One Earth Solar Farm

**Draft Statement of Common Ground with Nottinghamshire
County Council**

EN010159/APP/8.3.1

July-August 2025

Drawing Title:
Surface Water Drainage Strategy
Western BESS Compound

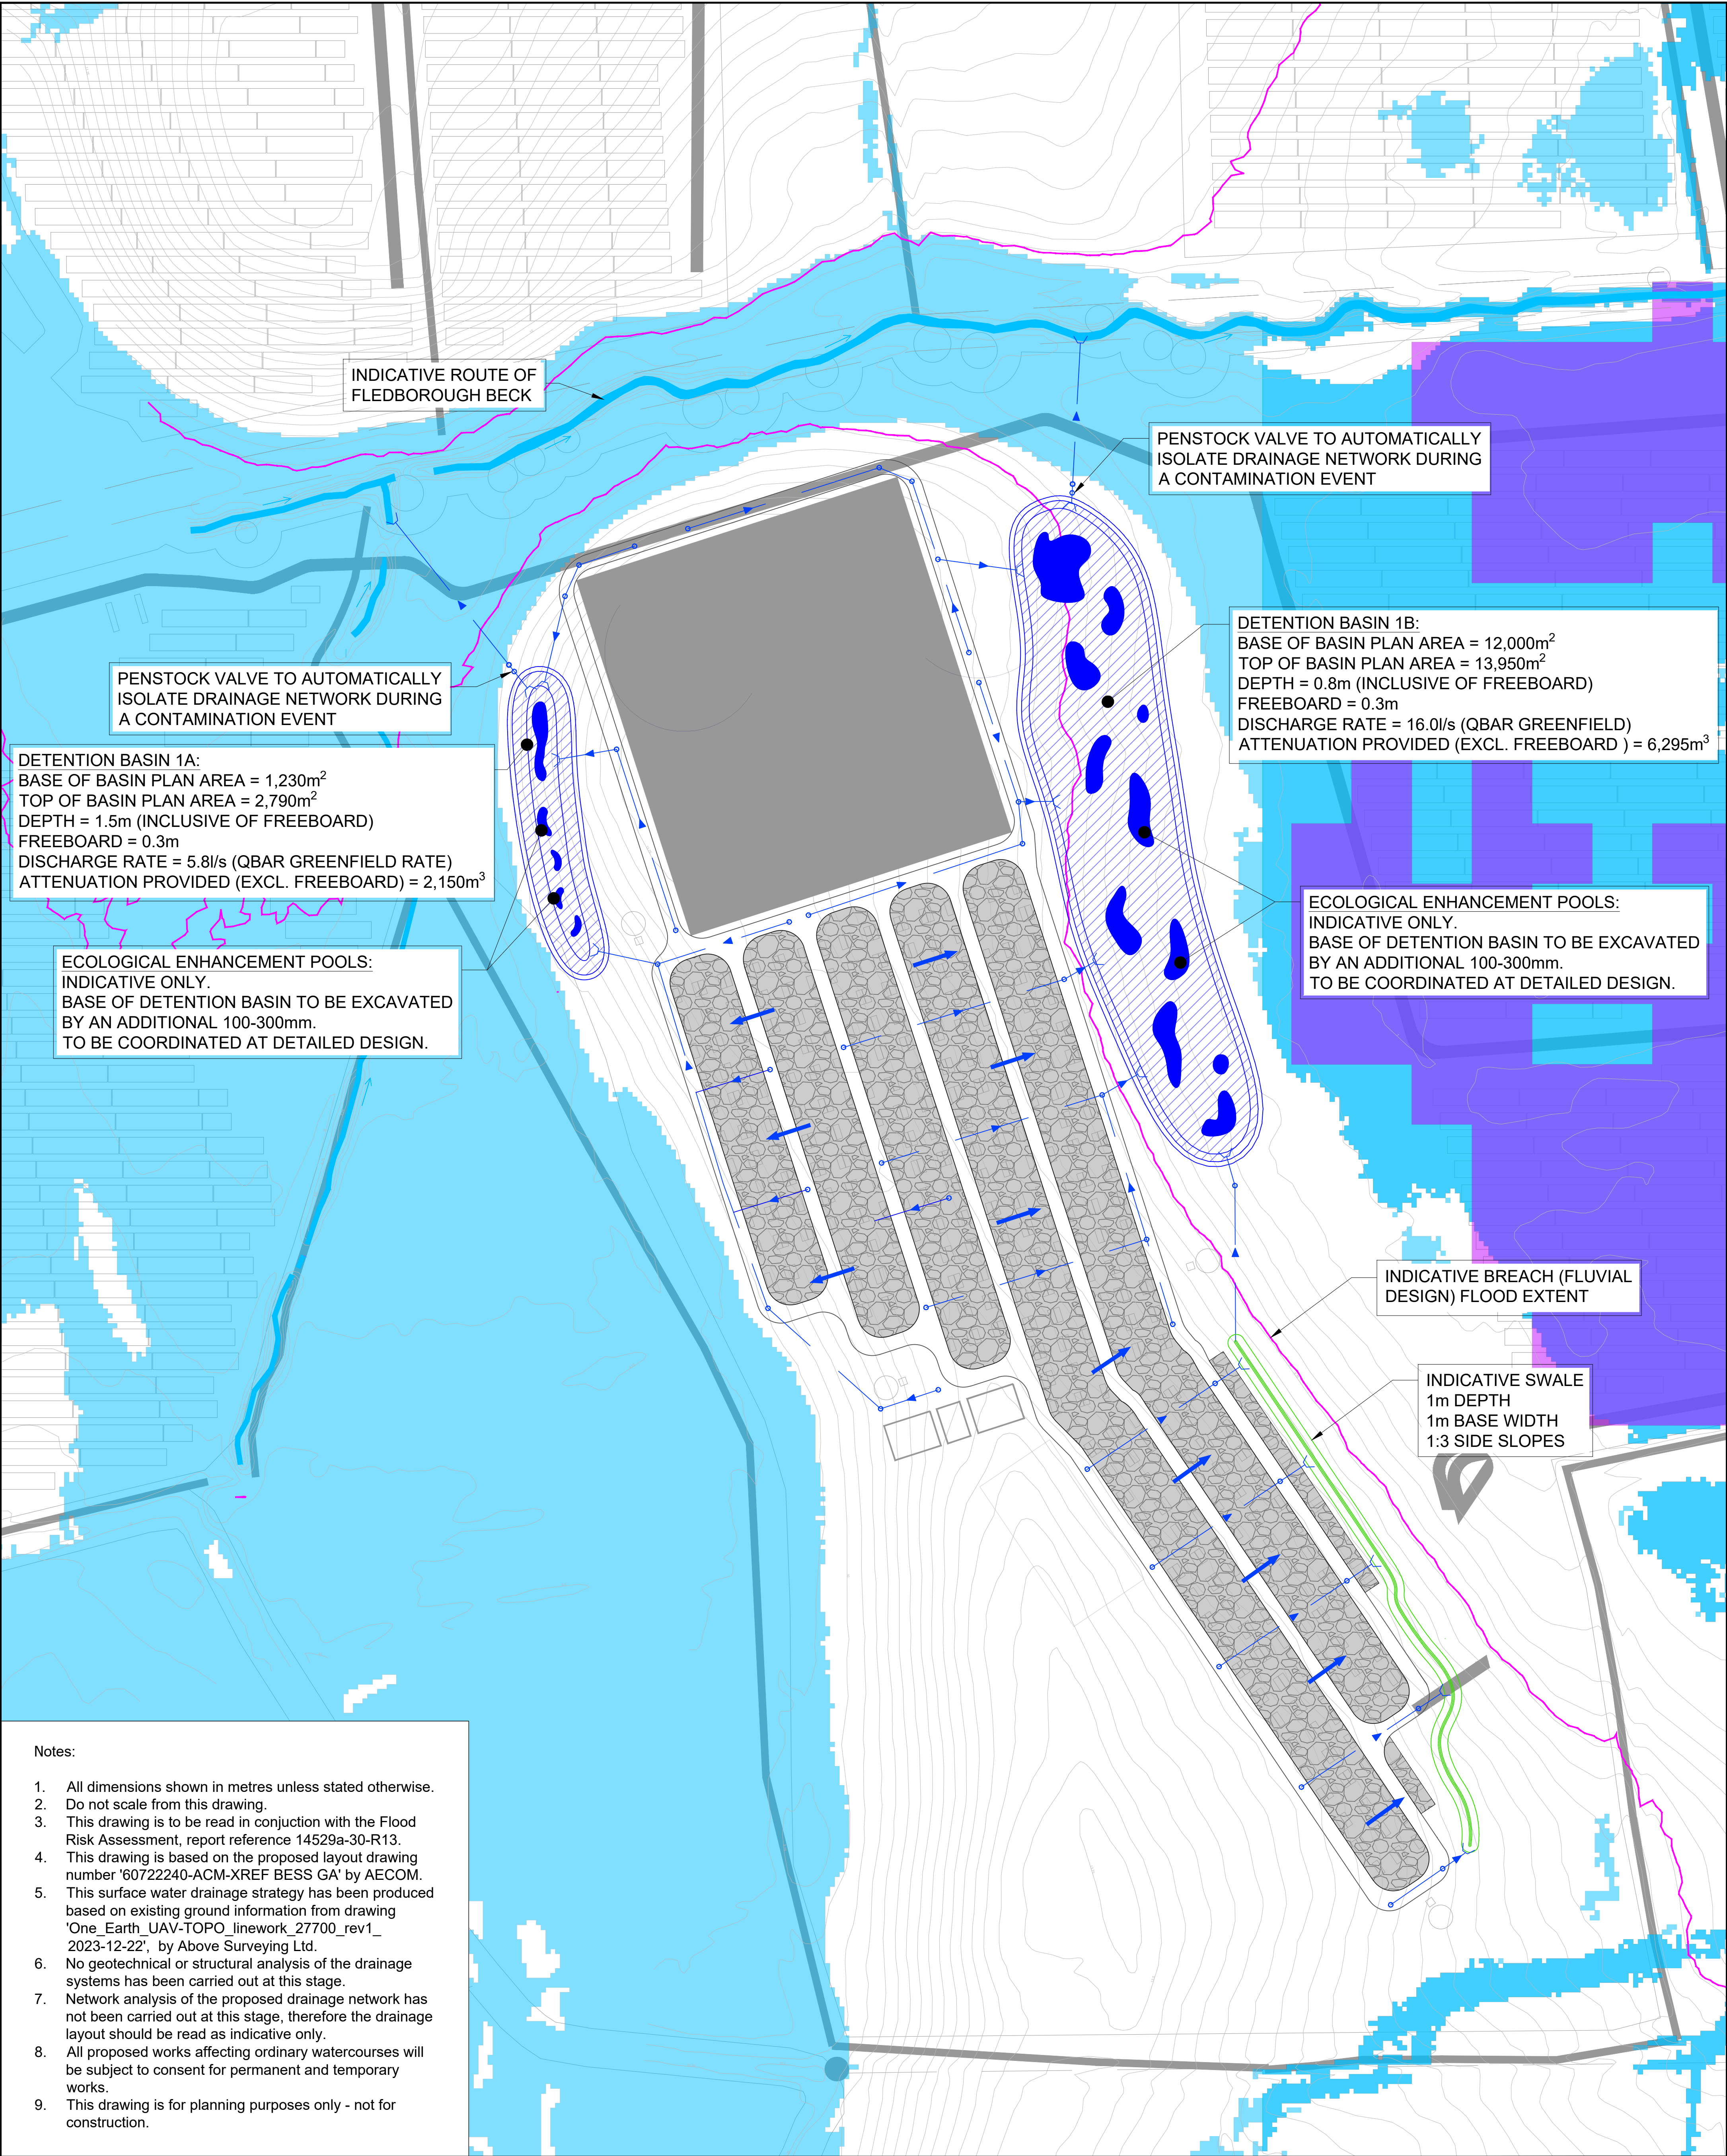
<u>09-03</u>	<u>Firewater Containment</u>	<u>Applicant to consider how surface water runoff from the BESS and Substation areas will be managed in line with local policy requirements.</u>	<u>The approach to management of firewater runoff has been agreed and is in line with that set out within the FRA as well as within Section 5 of the Outline Battery Safety Management Plan.</u>	<u>Under Discussion</u>

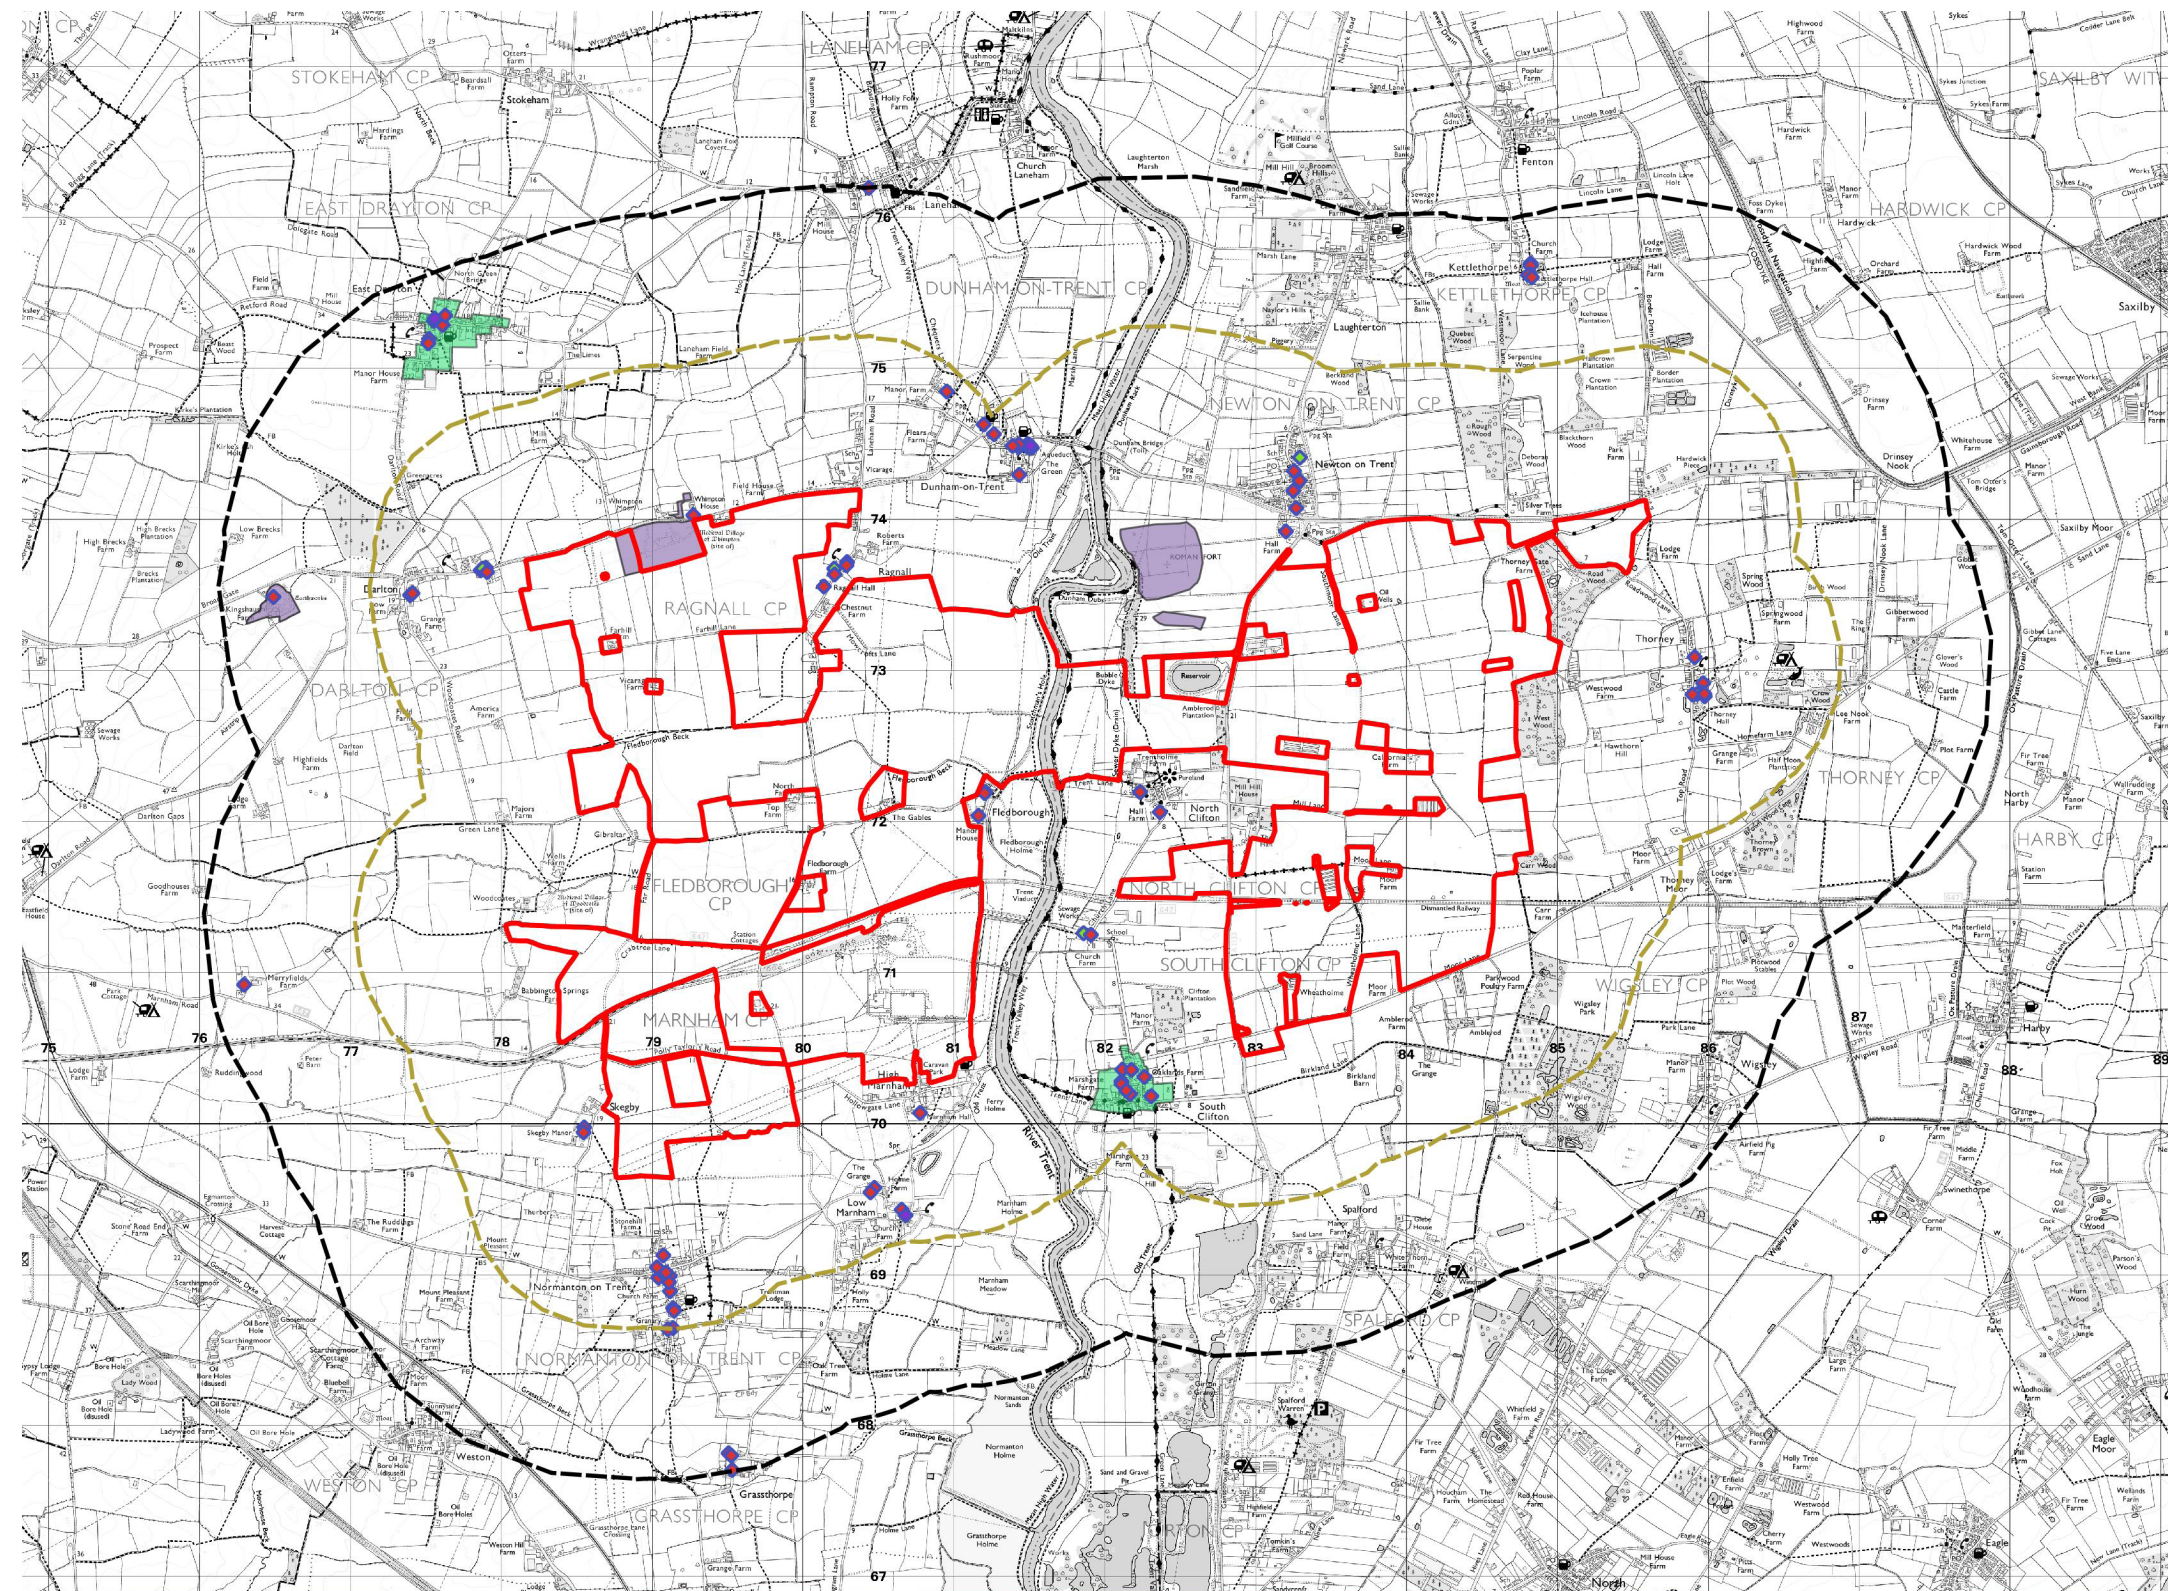
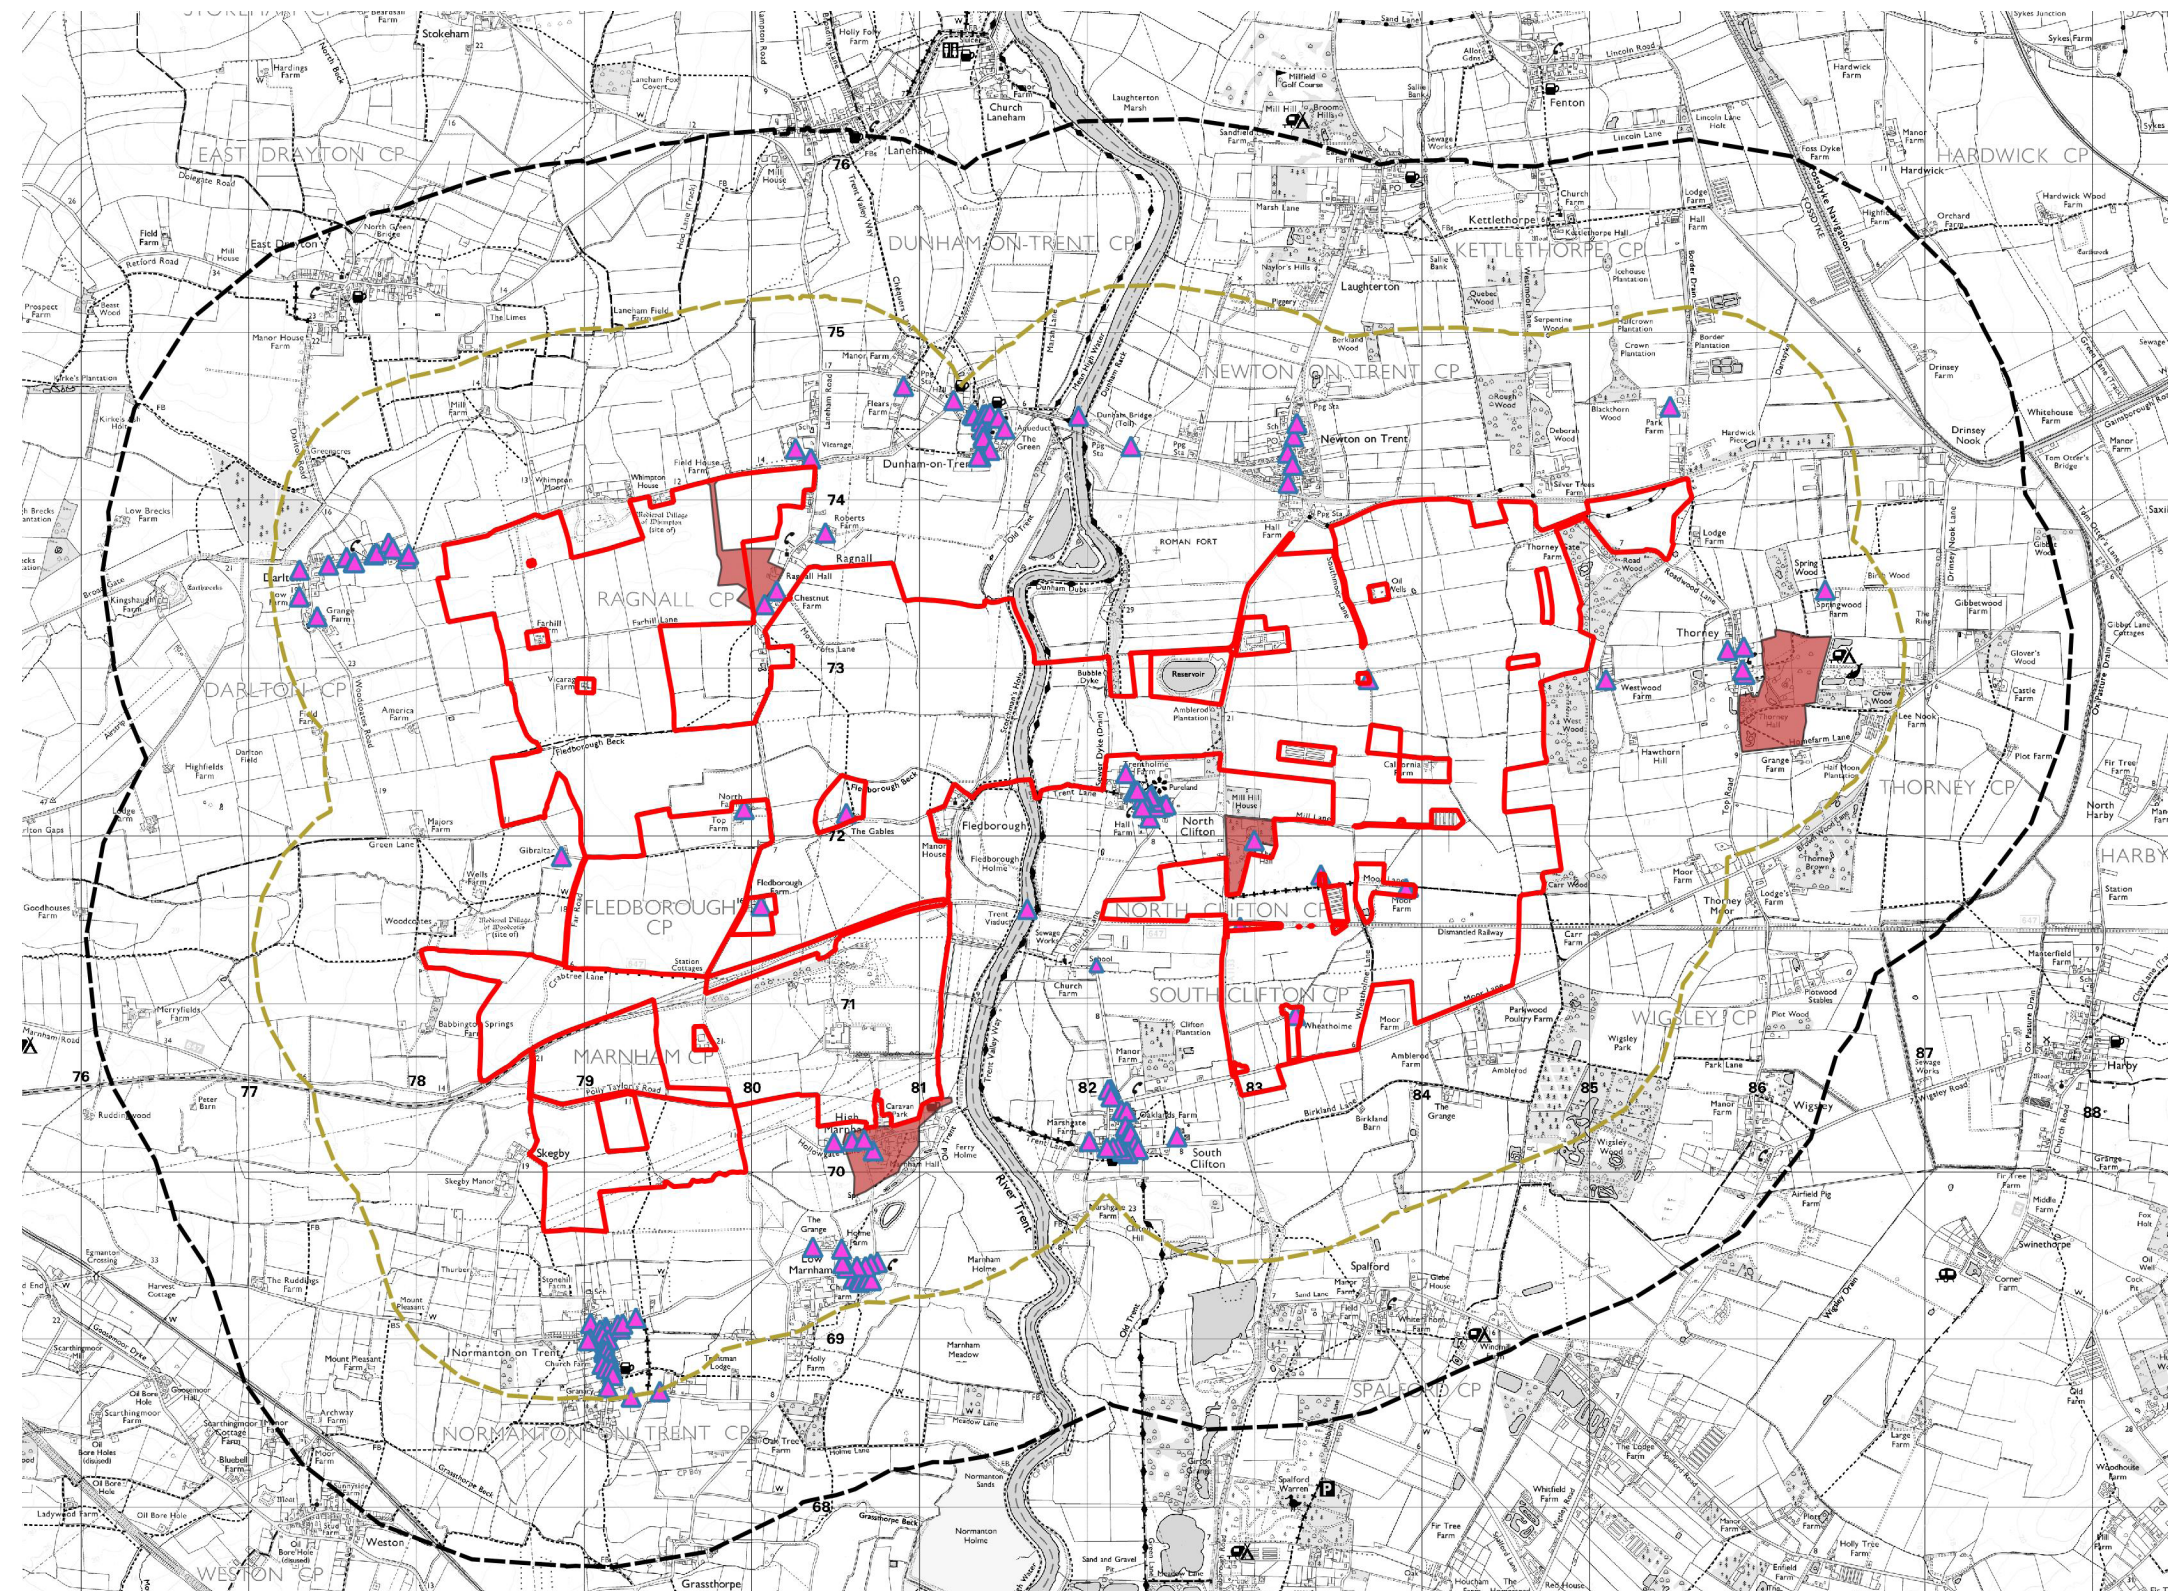
Discussion and agreement to review how the development relates to contouring to the north and northwest of St Leonards Church. It was agreed that topography would be overlayed onto the masterplan to demonstrate the relationship between the two.

Outcome: Order Limits are shown with topography overlay on page 8 of Technical Appendix 10.2 (APP-127). Discussion held on creating set backs to the east of Main Street and
